Banbury Oil Depot

Road Safety Audit Response Report

Report title:	Road Safety Audit Response Report – Banbury Oil Depot
Date:	13 th June 2022
Document Reference and revision:	22251-03
Prepared by:	DTA Transportation
On behalf of:	Oxfordshire City Council

Stage 1 Road Safety Audit

JOB TITLE		Banbury Oil Depot		CLIENT		The Motor Fuel Group	
DRAWING TITLE							
Proposed Development Access							
Footway Crossover and Vehicle Tracking (Refuse)							
SCALE	DRAWN BY	DATE	DRAWING No	REVISION			
@A3	DN	Sept 21	22251-04-1

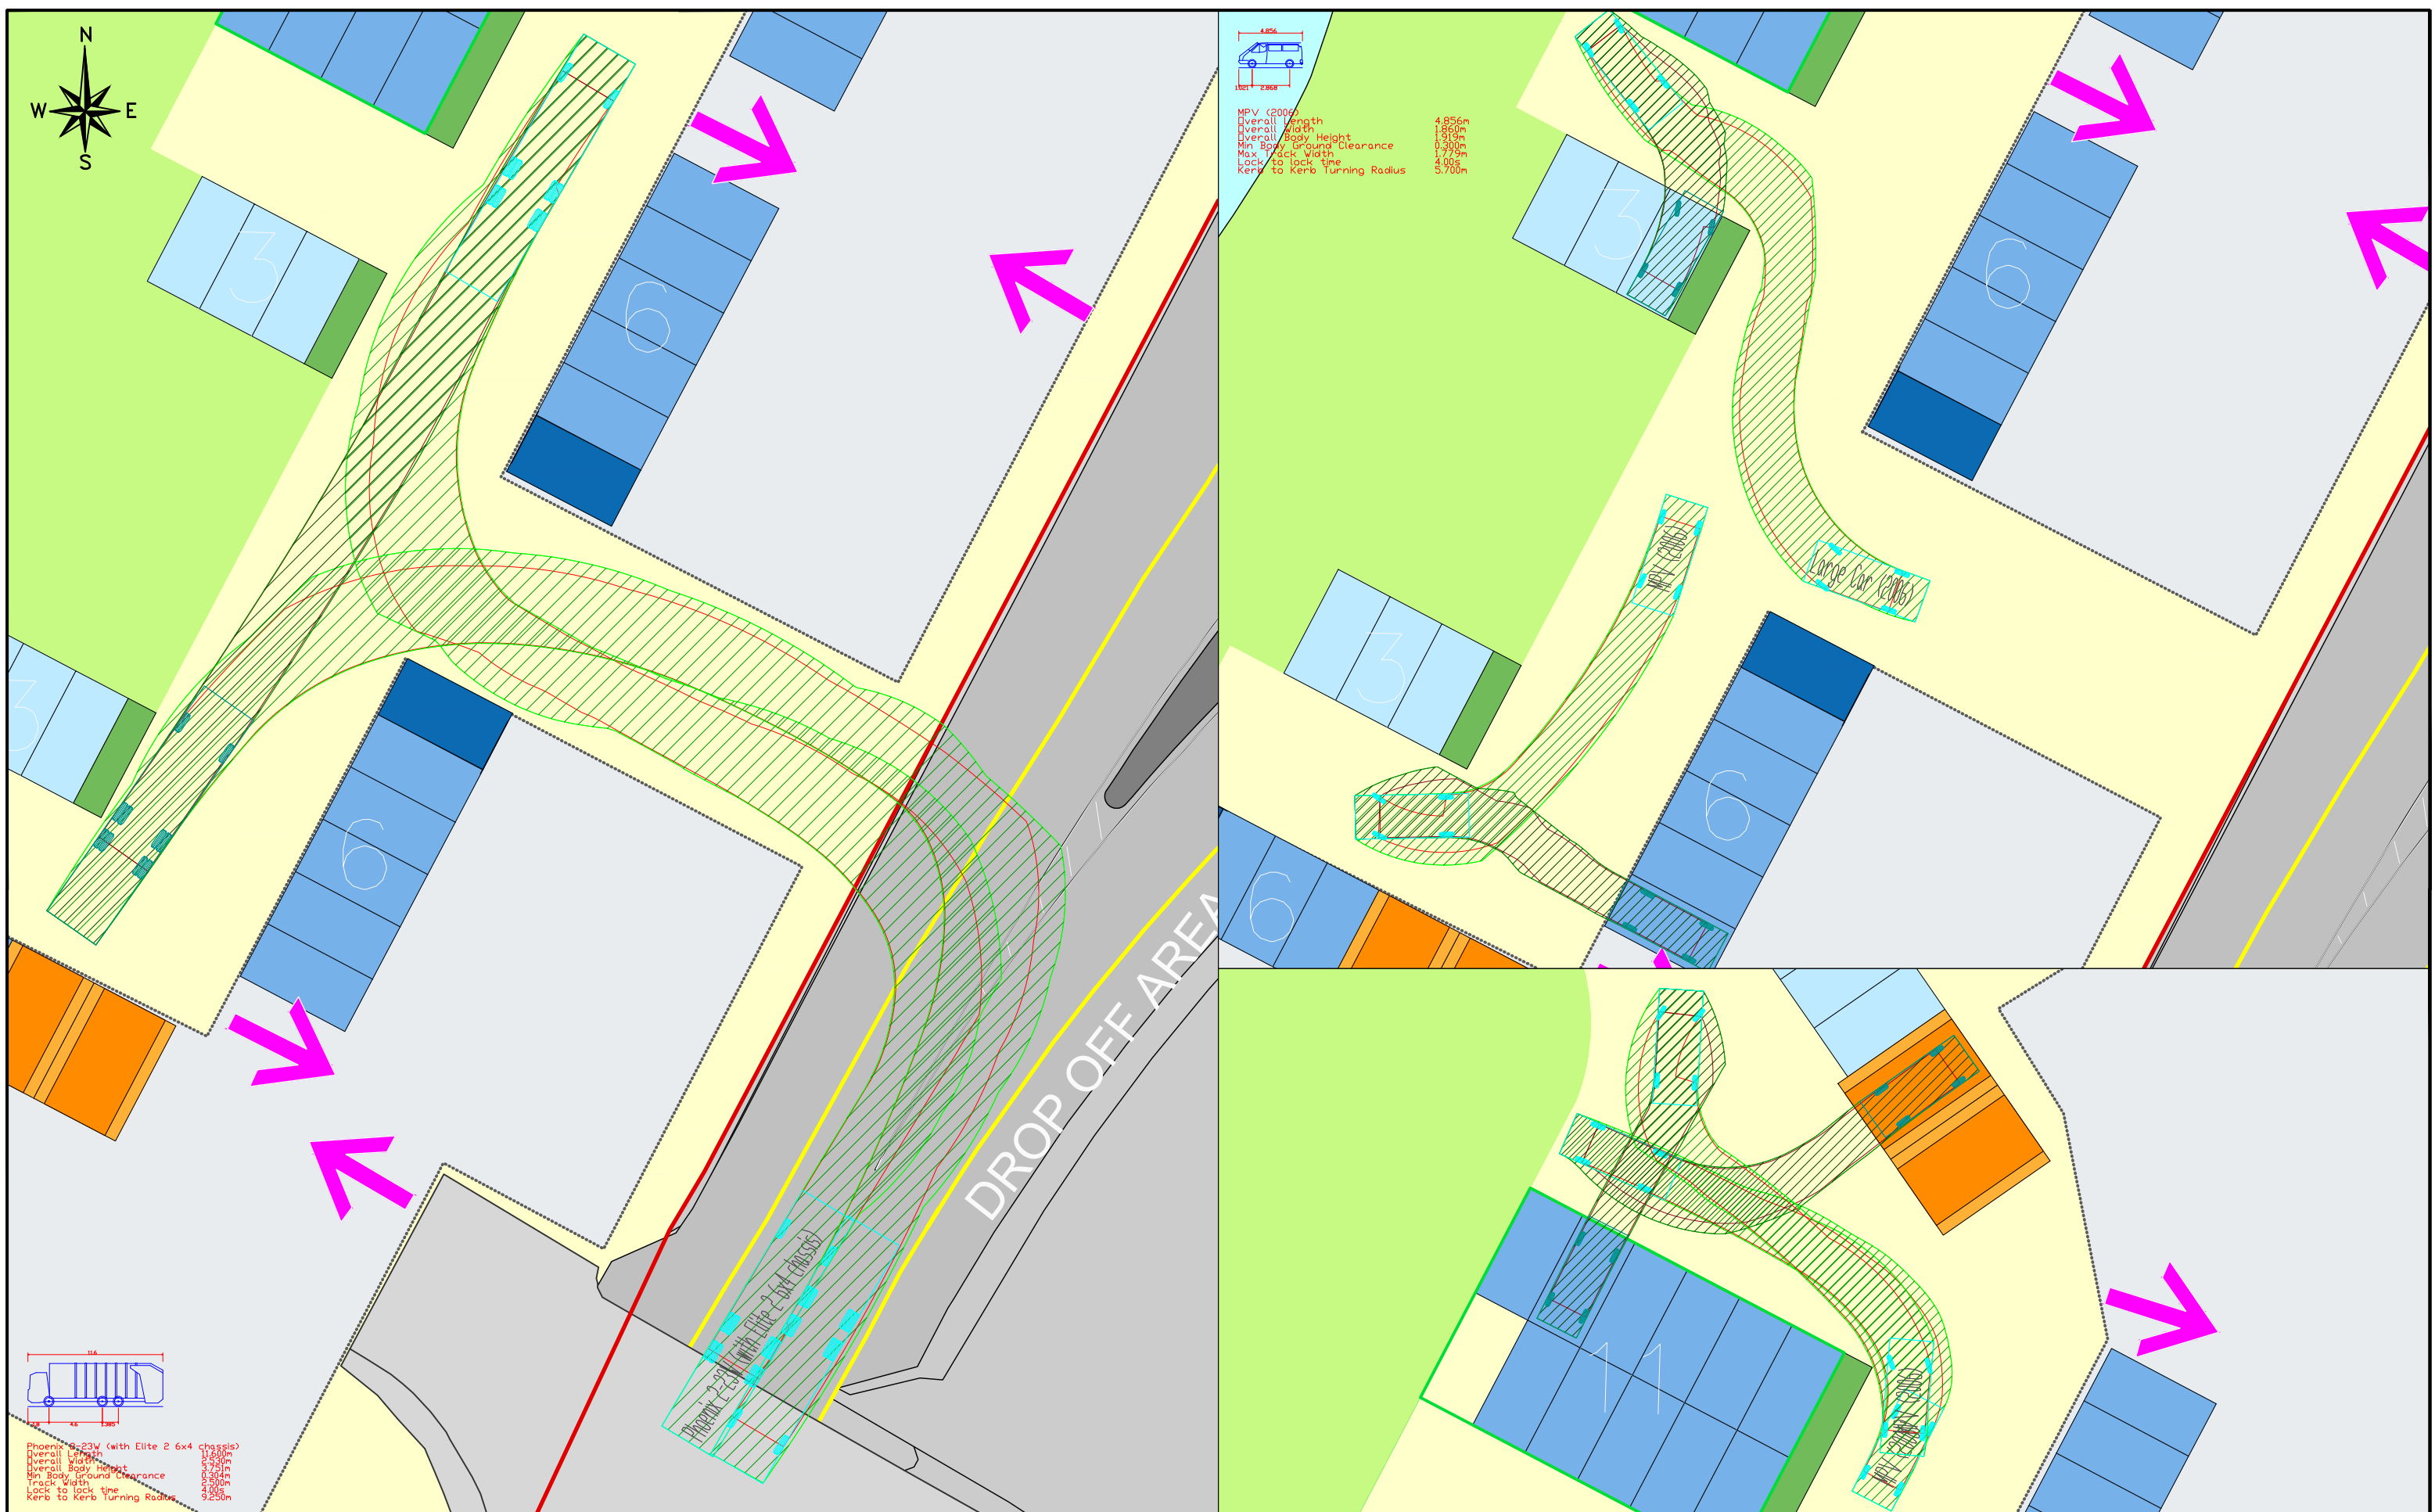
Summary: Change in use - hazard for
cyclists and pedestrians

The access joins a shared footway/cycleway and becomes a shared surfaced environment with vehicular traffic. Pedestrians and cyclists used to the existing layout may not be aware of vehicular traffic using this section of the road following the construction of the development. This may lead to collisions between vehicles and pedestrian or cyclists.

The inter-visibility between a driver exiting the access and a pedestrian or cyclist travelling towards the access in both directions may be restricted by the site boundary features. This may lead to a driver pulling out into the path of a pedestrian or cyclist resulting in collision and injury.

It is recommended that appropriate inter-visibility splays are provided at the back of the access and kept clear of obstructions. Measures should be implemented to highlight to all users that the area is shared surface environment.

RSA Problem	RSA recommendation	Design organisation response	Overseeing Organisation response	Agreed RSA action
<p>Problem: 4.1.</p> <p>Location: Proposed Access</p> <p>Summary: Change in use - hazard for cyclists and pedestrians</p> <p>The access joins a shared footway/cycleway and becomes a shared surfaced environment with vehicular traffic. Pedestrians and cyclists used to the existing layout may not be aware of vehicular traffic using this section of the road following the construction of the development. This may lead to collisions between vehicles and pedestrian or cyclists.</p> <p>The inter-visibility between a driver exiting the access and a pedestrian or cyclist travelling towards the access in both directions may be restricted by the site boundary features. This may lead to a driver pulling out into the path of a pedestrian or cyclist resulting in collision and injury.</p>	<p>It is recommended that appropriate inter-visibility splays are provided at the back of the access and kept clear of obstructions. Measures should be implemented to highlight to all users that the area is shared surface environment.</p>	<p>The problem and recommendation are accepted.</p> <p>Drawing 22251-04e-1 shows that the existing kerb line will effectively become the back of the proposed footway/ cycleway (Blue Dashed Line)</p> <p>The development is dedicating additional room along the frontage of the site to assist with the delivery of an improved footway/ cycleway.</p> <p>All vehicles entering and exiting the site will have appropriate visibility of users of the footway/ cycleway before pulling out onto Tramway Road</p>
